**MAINE MEDICAL CENTER
MEDICAL OFFICE BUILDING
PARKING STRUCTURE AND
OVERHEAD CONNECTOR**

**883 - 887 CONGRESS STREET
PORTLAND, MAINE**

**Re: Response to Jaimey Caron's December 11, 1997 Memorandum
Maine Medical Center Office Building
Congress Street**

**RE: Maine Medical Center
Medical Office Building**

LEVEL 2
LIGHTING Layout

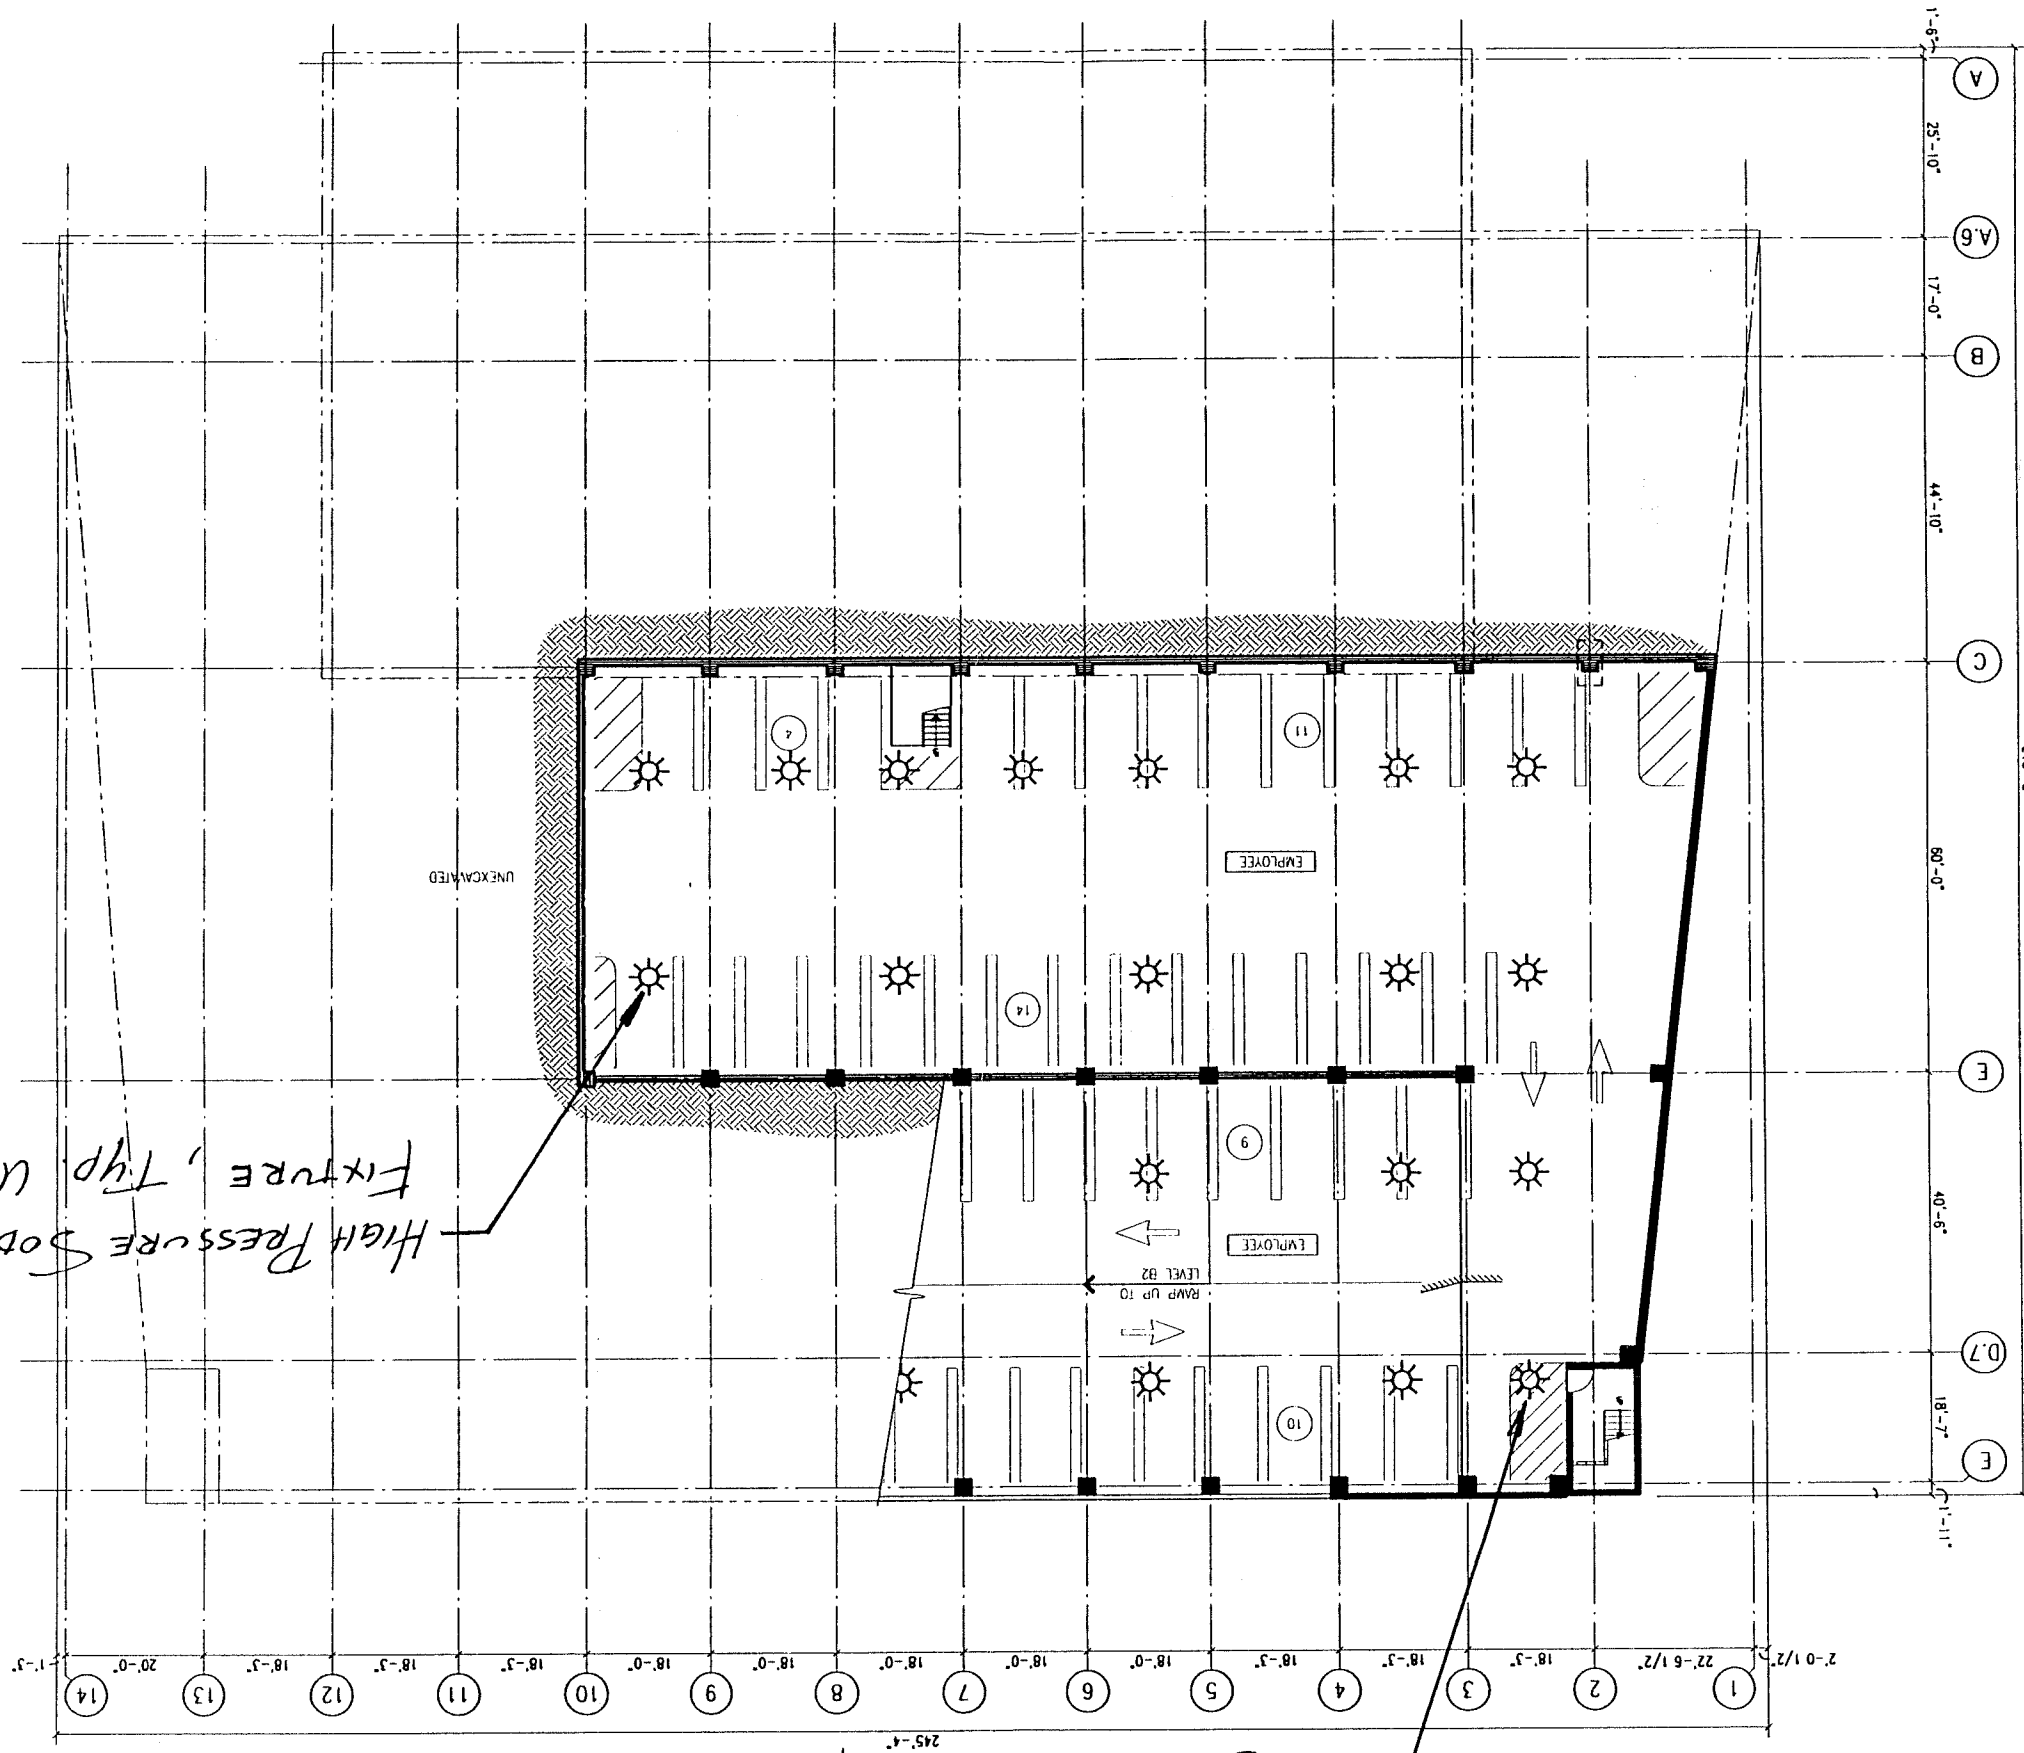
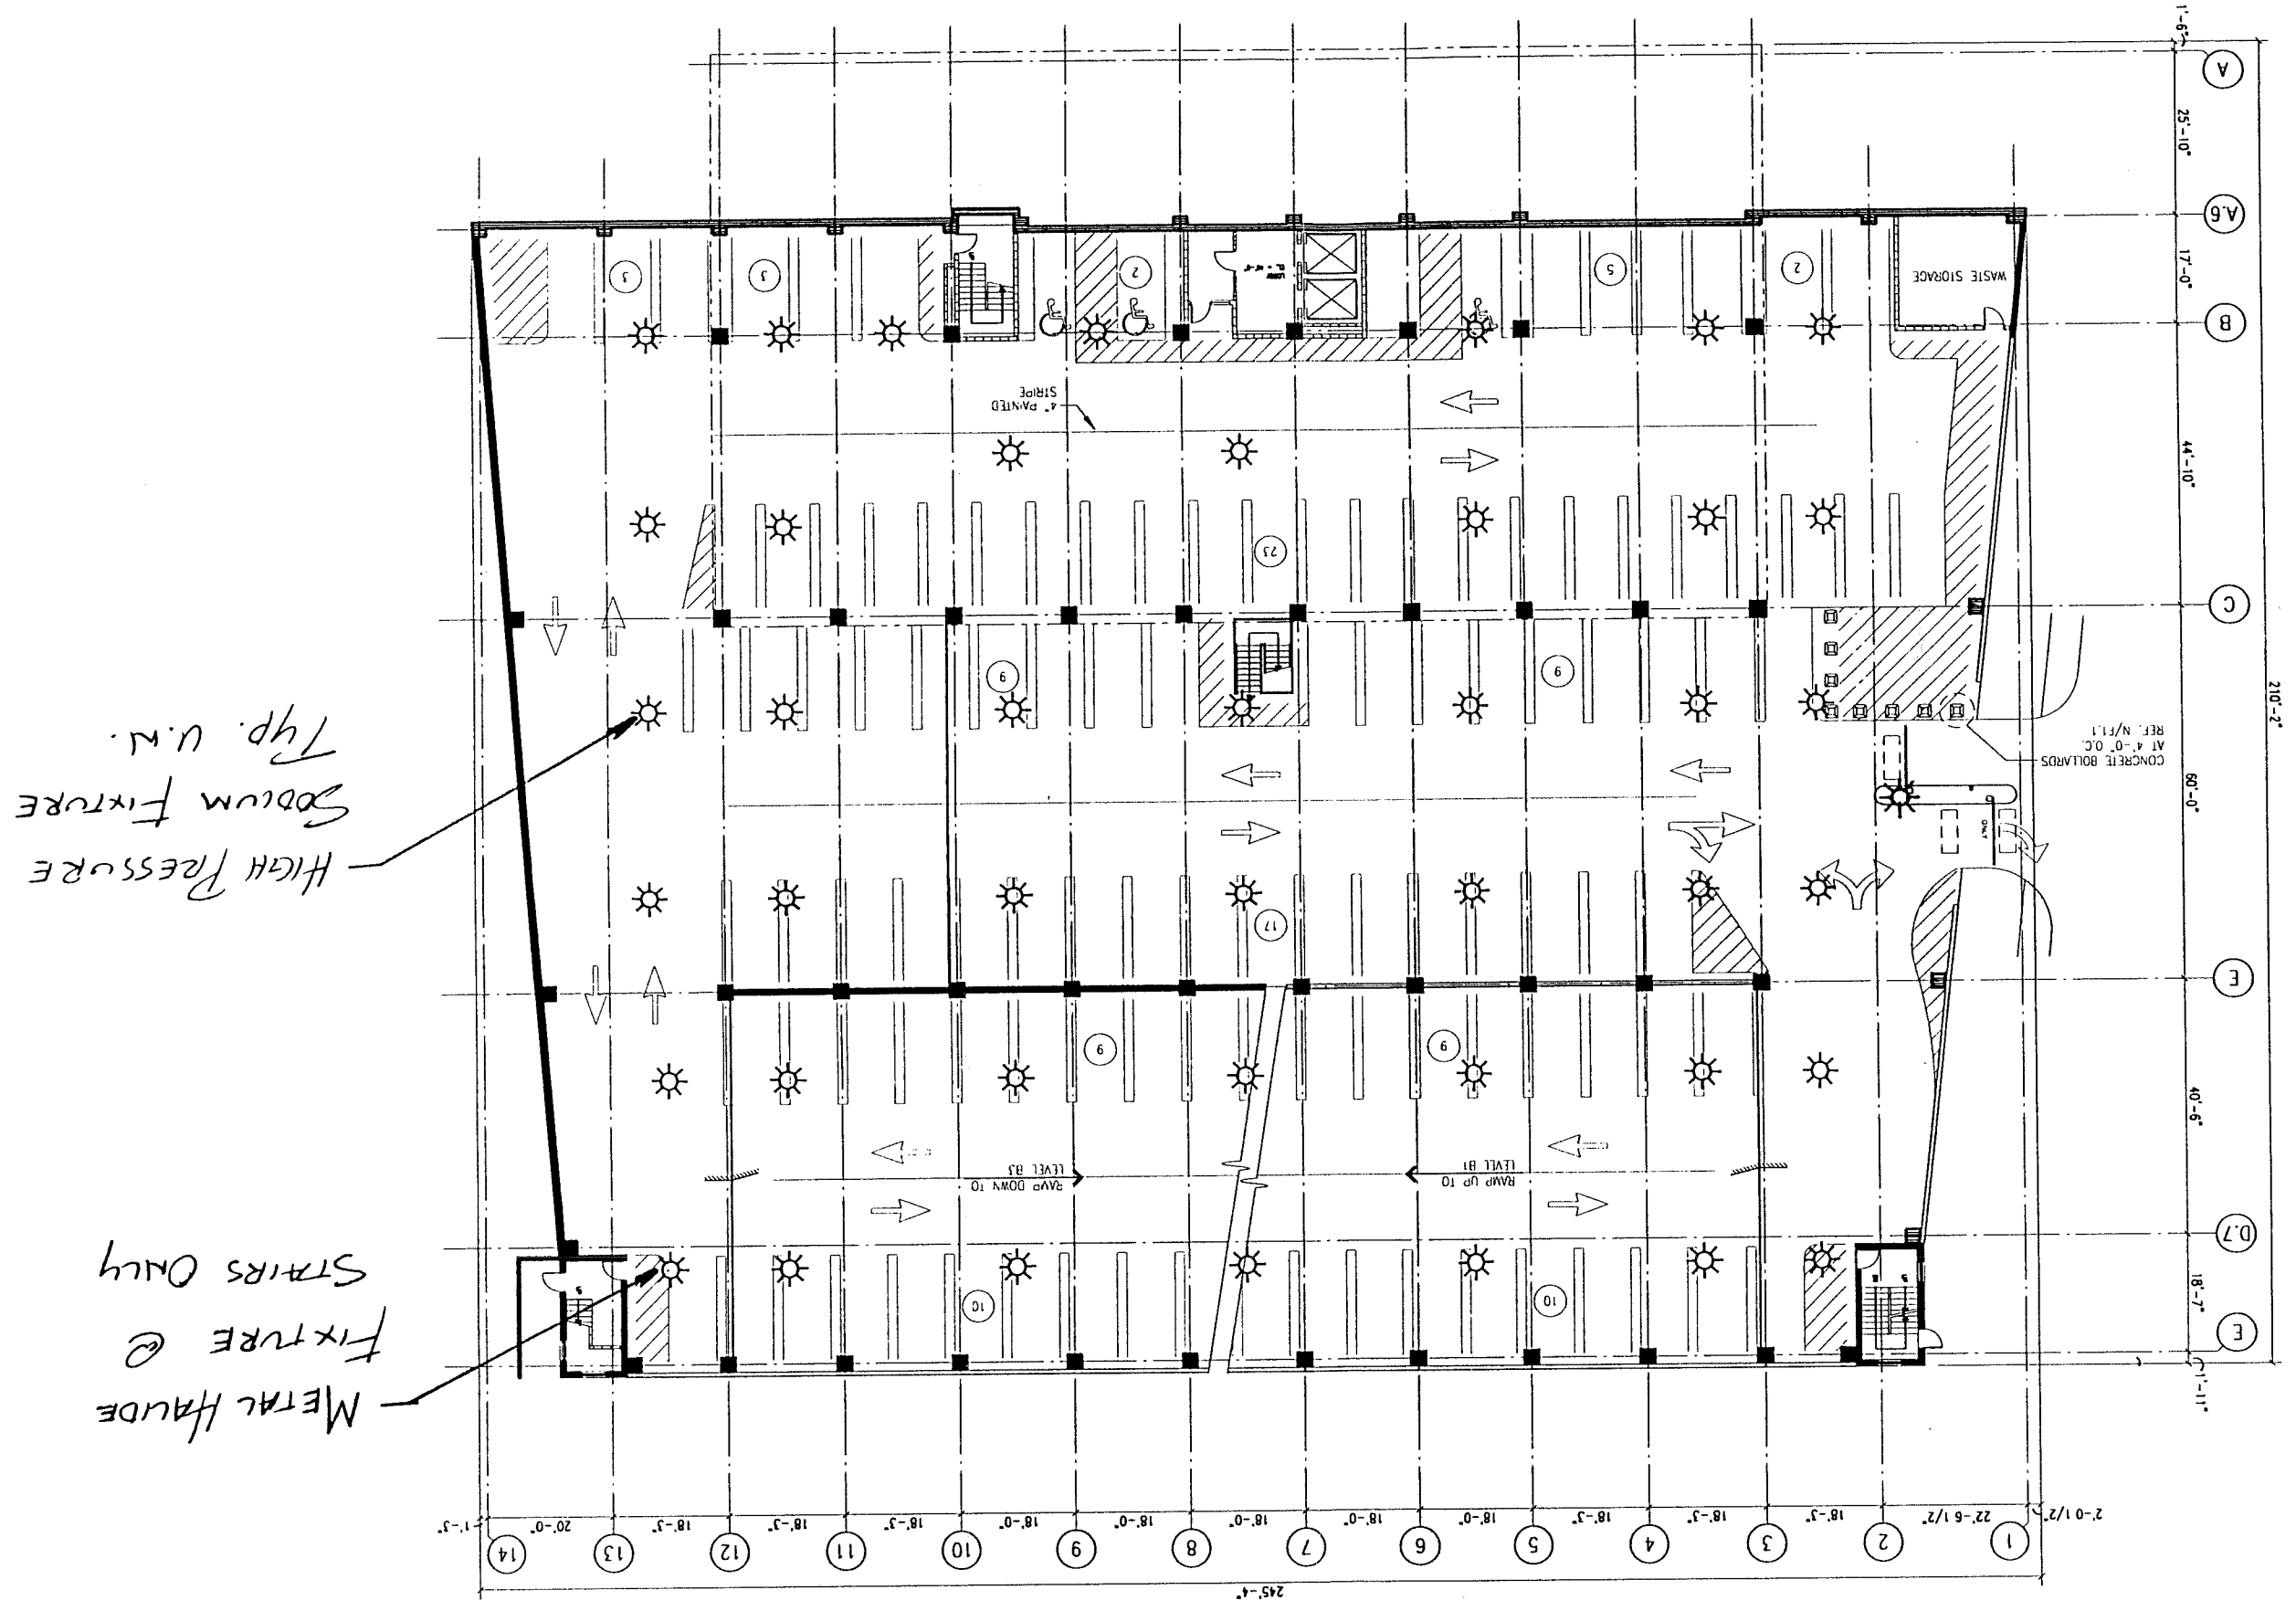
In the event that light poles on the roof of the garage are included in the final submission, I would like a condition of approval crafted that would restrict the height and location so as to be inconspicuous to the surrounding neighborhood on three sides.

MMC continues to work with the staff on the lighting issue.
